STATE OF NORTH CAROLINA  
DEPARTMENT OF TRANSPORTATION

January 17, 2008

**SUBJECT:** Request For NW 23/33 Permit Modification and NW 13 for the replacement of Bridge No. 122 over Sandy Creek and Bridge No. 217 over a tributary to Sandy Creek on SR 1116 in Durham County, Federal Project No. BRSTP-1116 (4), State Project No. 8.2353001, Division 5, WBS Element 33070.1.1, T.I.P. No. B-3450.

GENERAL DRAWING
BRIDGE OVER TRIBUTARY
TO SANDY CREEK ON SR 1116
BETWEEN SR 2220
AND US 15/501

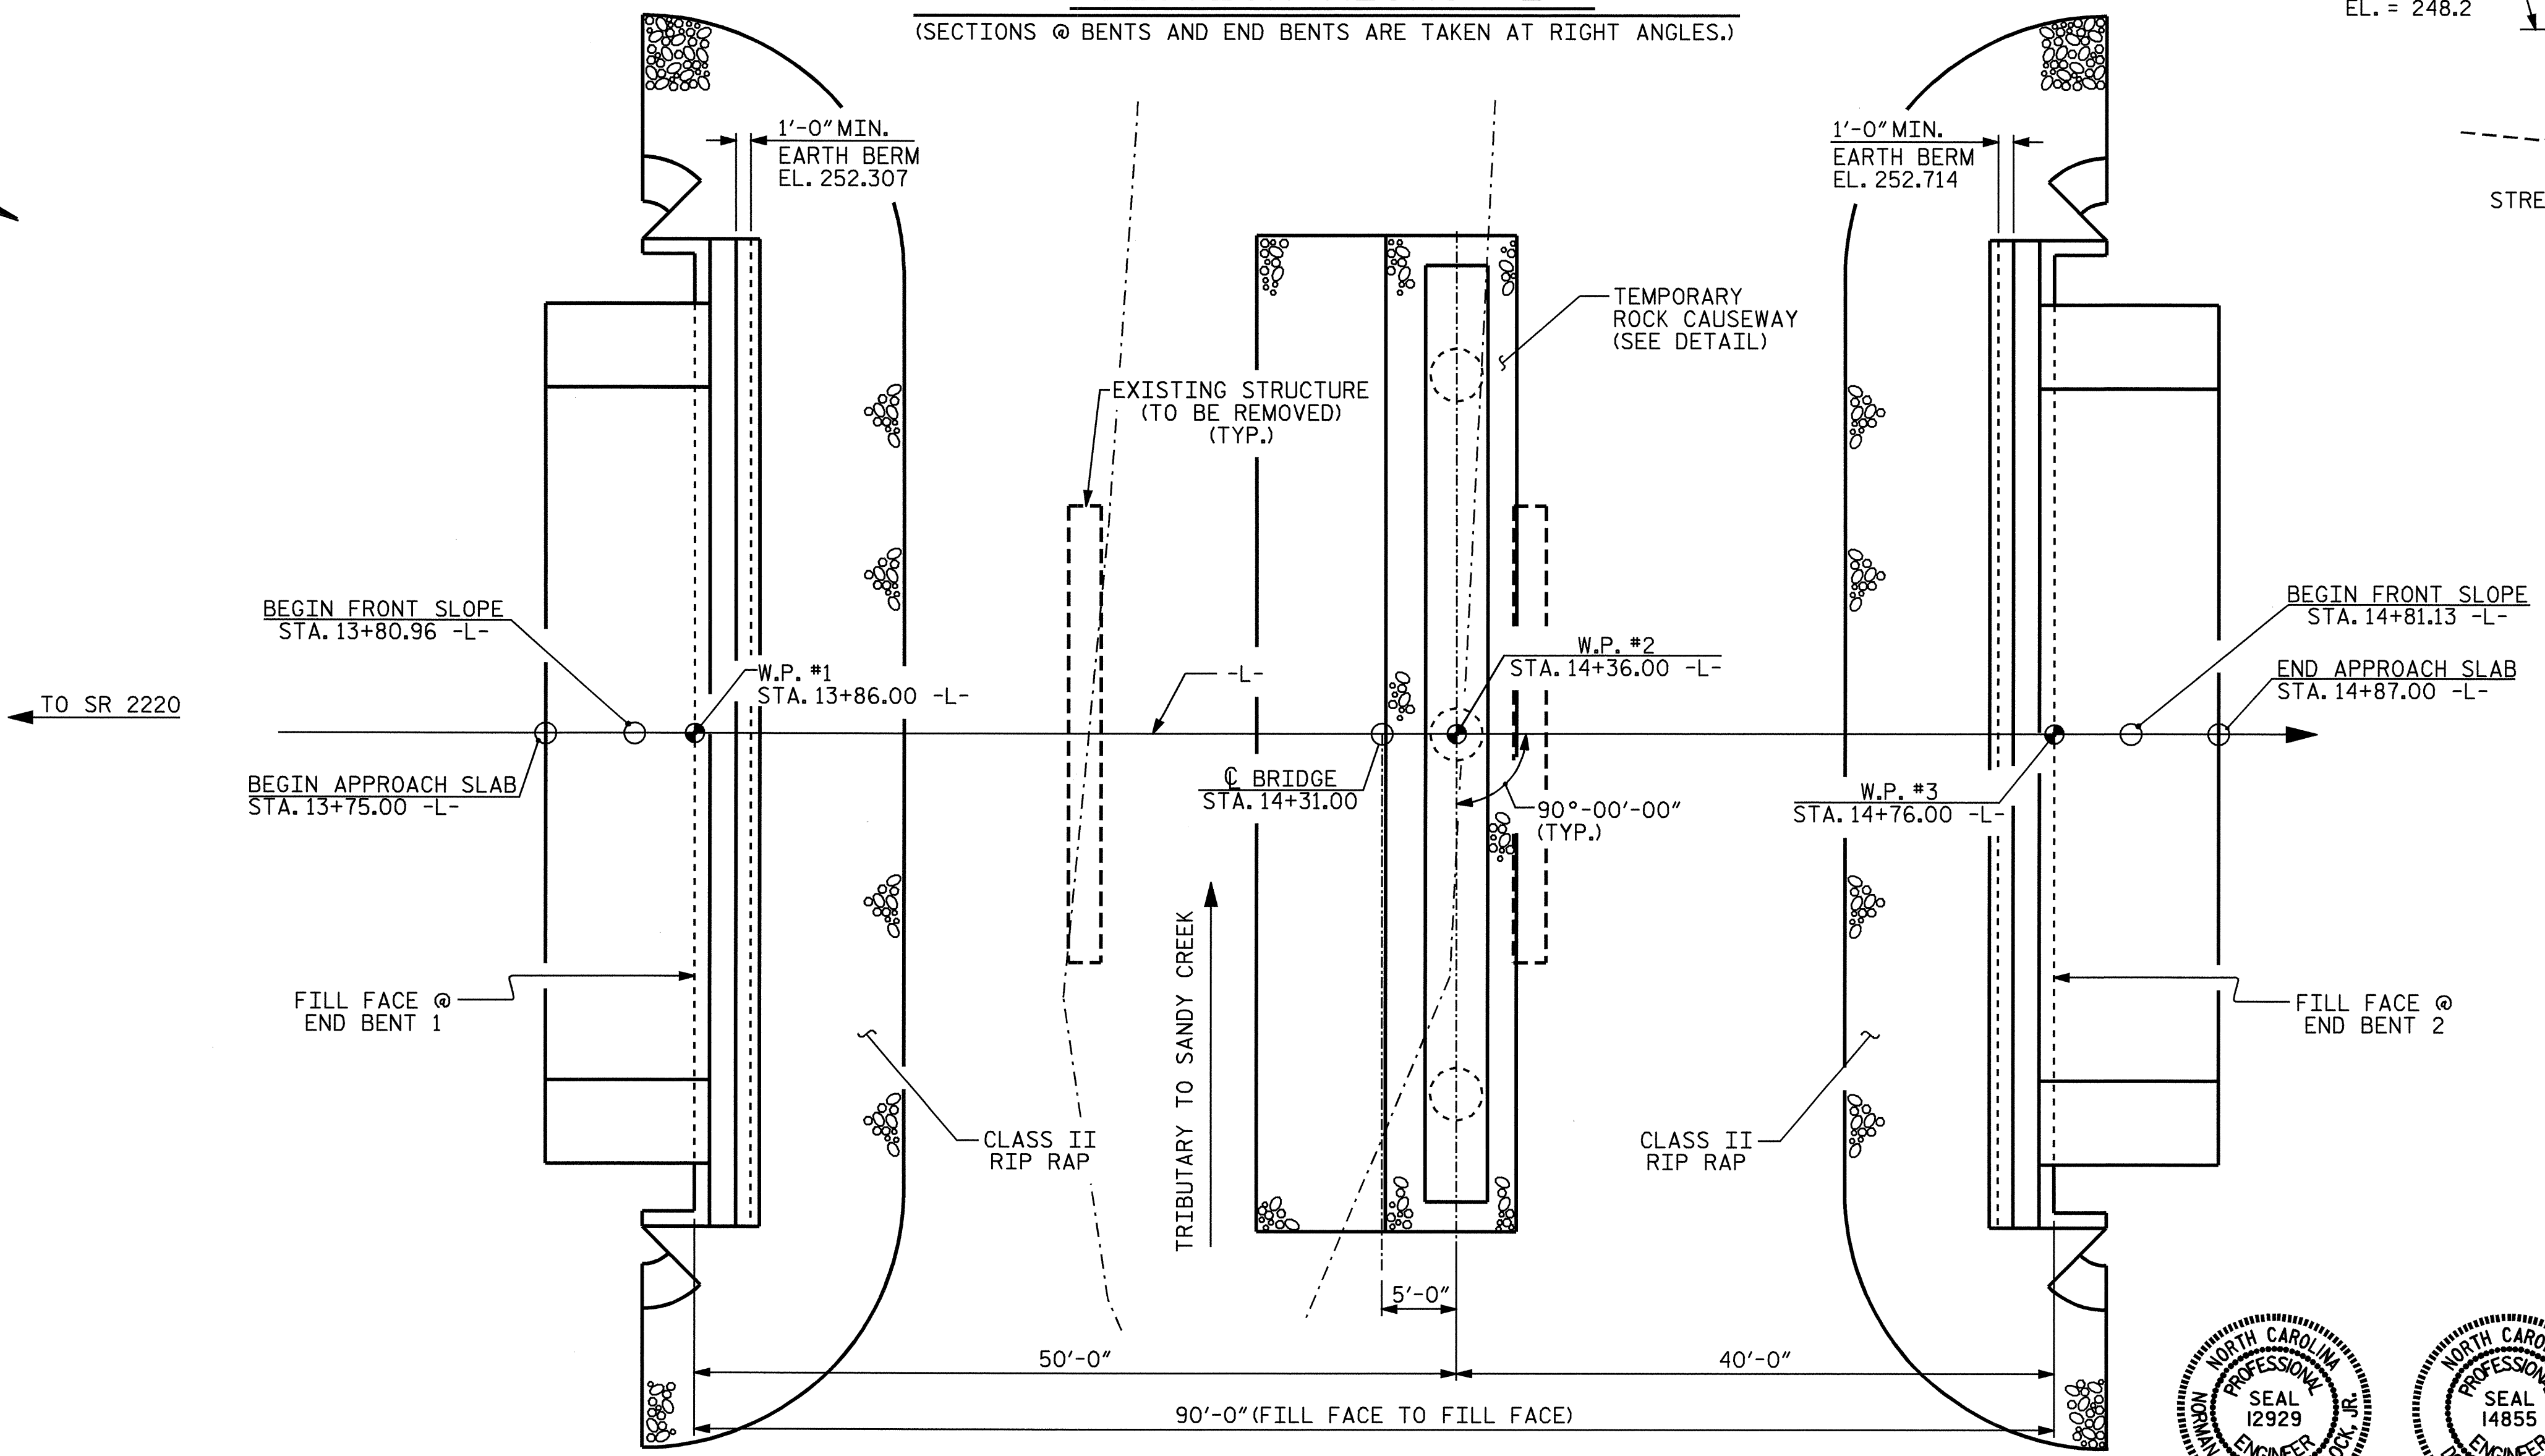
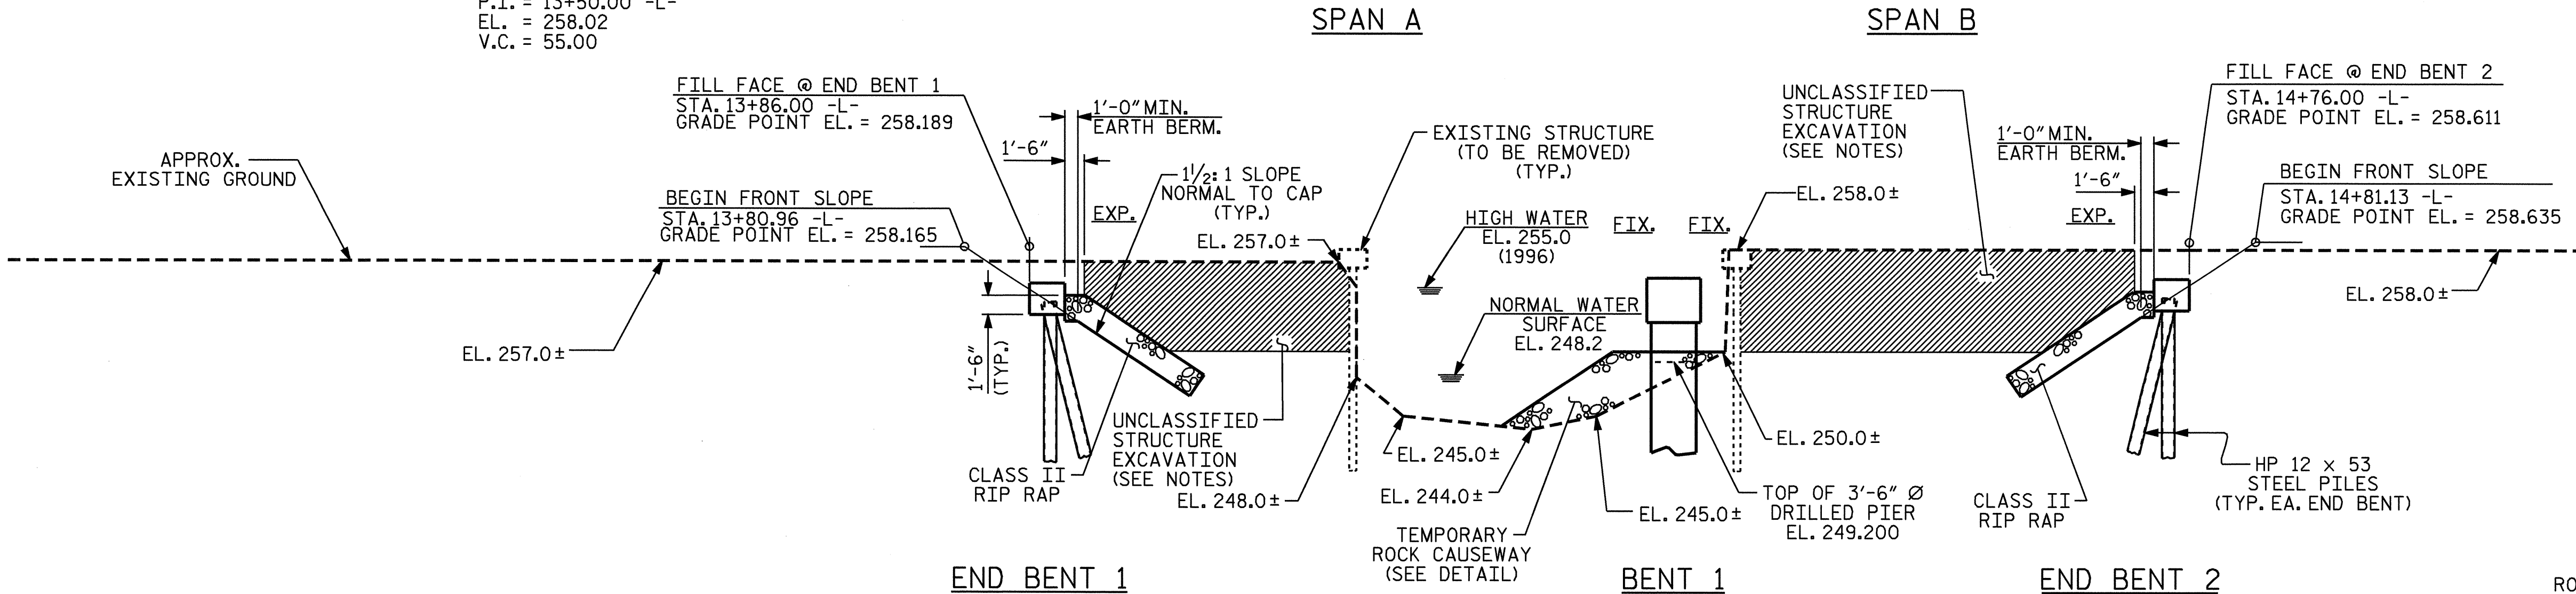
Background: The Department has determined that pre-formed scour holes (PFSHs) located at Stations 13+30 Lt and 15+57 Lt must be re-sized due to changes in the hydraulic design. The

PFSH located at 13+30 Lt will be increased from a 6' x 6' device to a 12' x 12' device. The PFSH located at 15+57 Lt will be increased from a 4' x 4' devices to a 6' x 6' device. The construction of the devices will result in additional impacts to wetlands.

Jurisdictional changes: The construction revision will result in new impacts of 0.003 excavation in wetlands and an increase of 0.02 acres mechanized clearing in wetlands.
